MMO Reference: DCO/2024/00007
Planning Inspectorate Reference: EN070009
Identification Number: 20049273

16 September 2024

**Planning Act 2008, H2 Teesside Limited, Proposed H2 Teesside Order
Deadline 1 Submission**

Figure 1: Distances from River Tees HDD pits to MHWS. Information and images provided by H2 Teesside Limited.

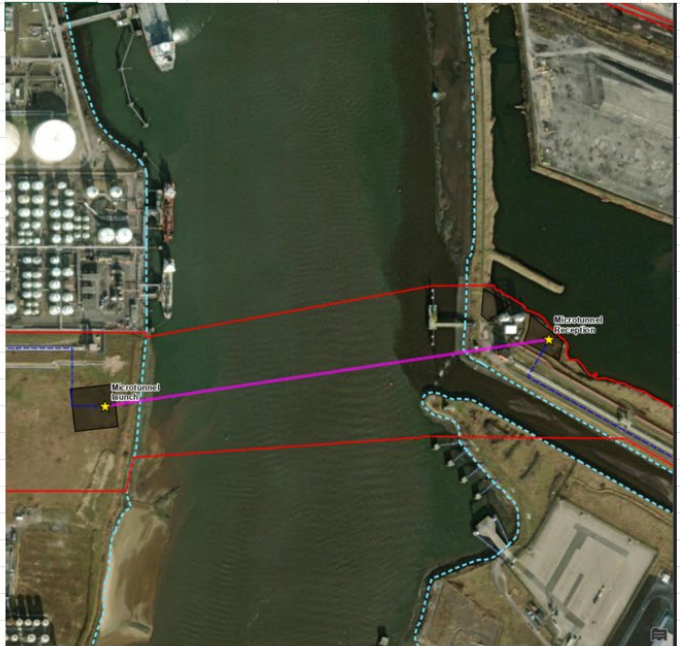
3.1.3 Whilst the MMO is content that the crossing entry and exit pits are above MHWS, we would like to see the distances referenced to the MHWS mark and we query what data set has been used to obtain the MHWS location.
